SURFACE WATER DRAINAGE – SUPPLEMENTARY REPORT LAND TO THE REAR OF SUNNYSIDE BARN AND FLINT BARN, BARNHAM

For Manorwood Ltd

Report Number: YE4281, Date: May 2020

Figure 2: Proposed Drainage Strategy

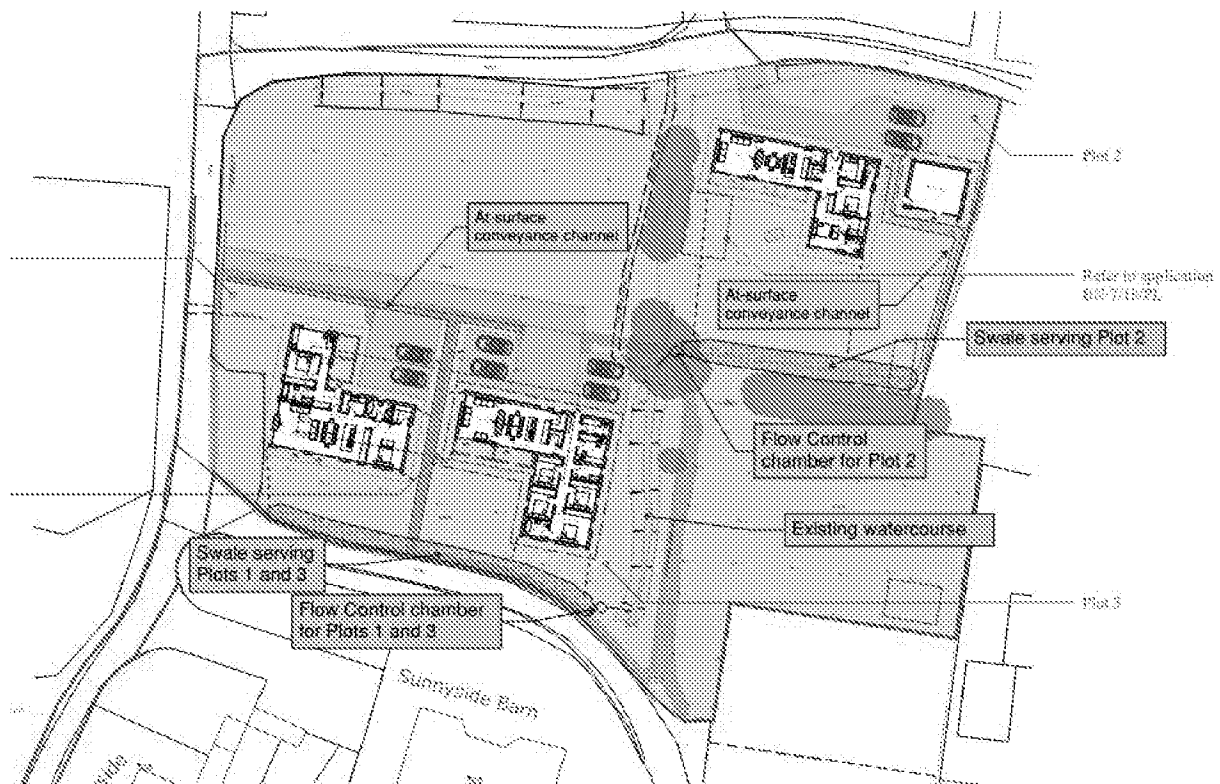
We do not accept orifices of less than 50mm as control devices due to the risk of blockage causing flooding upstream. On this basis the calculations will likely change with the inclusion of alternative flow control devices.

Arun DC queried whether the contributing areas draining to the swales included the areas of the swales themselves. They did not.

As an alternative, hydrobrakes have been incorporated into the detailed design which provide the necessary control to the discharge rates whilst maintaining an orifice size of at least 50mm.

The plan and table below identify the total areas draining to the swales which has been used in the updated hydraulic modelling (see Section 9).

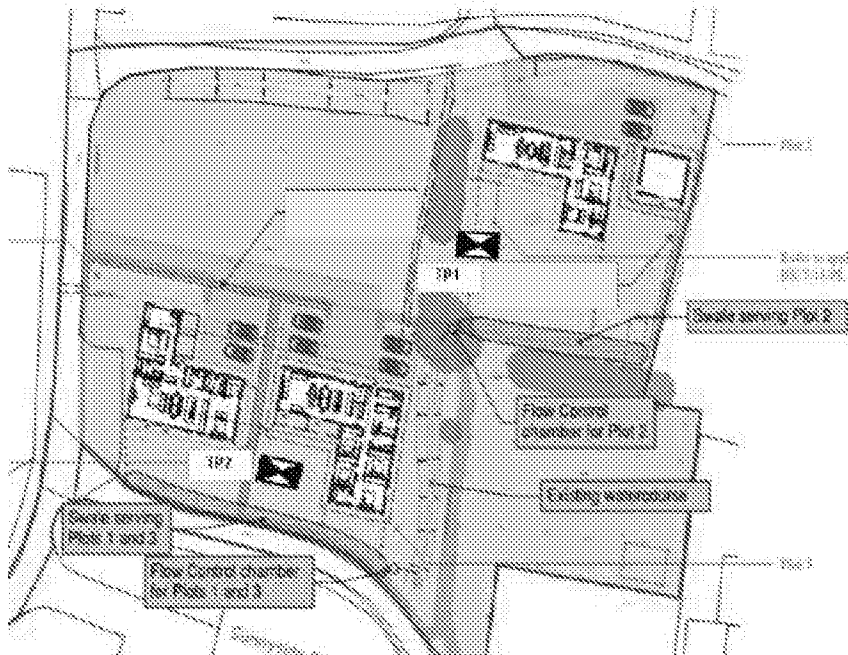
- The groundwater level identified as part of the infiltration testing is unclear. The results state that each pit "filled 60cm within 20mins" from a starting point of 0.9mbgl and 0.7mbgl. On this basis we have read the results as peaking at 0.1mbgl in TP2. (Rather than both pits stabilising at 0.6mbgl). If this is the case the swales will require impermeable liners to avoid groundwater ingress, this will require the design to account for buoyancy. If the groundwater is in fact at 0.6mbgl then the applicant is advised to approach this department to discuss any further required monitoring and/or design options.

It is agreed that the data as presented could have been made more clear. During the excavation of the trial pit water ingress was noted at 0.9m bgl and was reported (verbally) to be perched groundwater which did not prevent the excavation from continuing to the target depth of 2.0m bgl. Once the excavation was complete water filled the excavation by 60cm (to 1.4mbgl) within 20mins. It is our contention that the design groundwater level is at 1.4m bgl (at TP1 and at TP2).

The Trial Pits were excavated in the positions shown below (not provided in the previous report). The ground levels at these locations are approx. 9.3m AOD for TP1 and approx. 9.1m AOD for TP2. Therefore, it may be stated that the groundwater level in TP1 has been measured at approx. 7.9m AOD at TP1 and at 7.7m AOD at TP2.

Appendix E - Headwall details

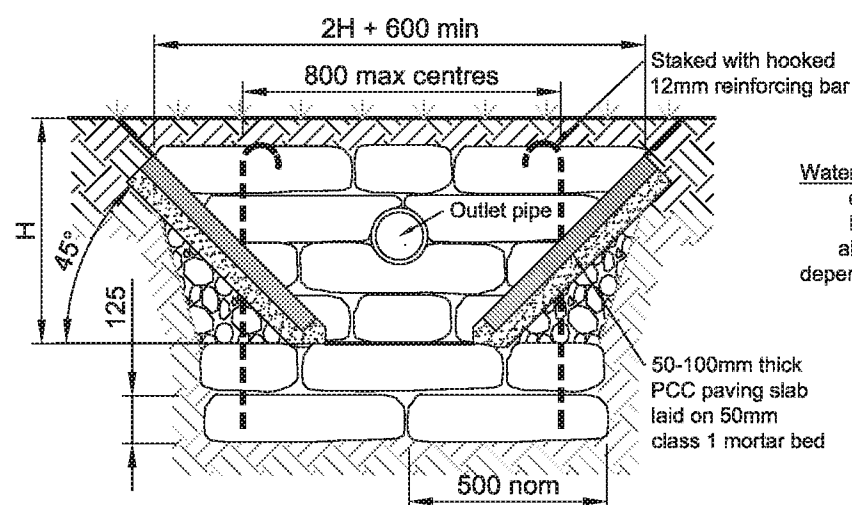
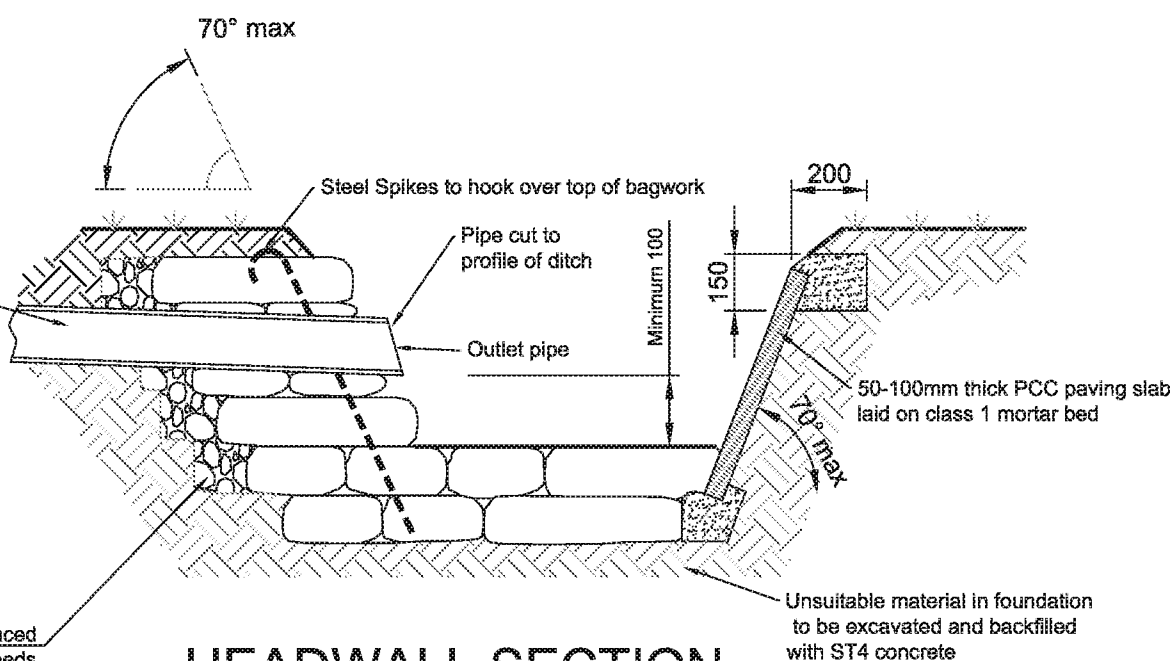
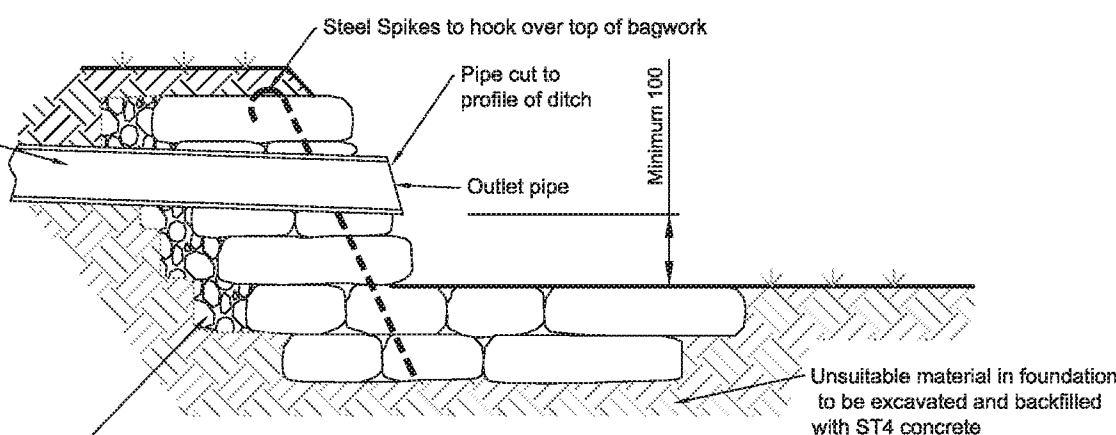
6. The downstream culvert (which the watercourse leads to) has known issues. The applicant will likely need to undertake offsite improvements to this to ensure it is fit for purpose. The same is likely to be applicable for the headwall and ditch onsite.

A headwall detail for incoming pipes into the swale and the outgoing pipes is provided in Appendix E. This detail is reproduced from the West Sussex CC suite of highways drawings.
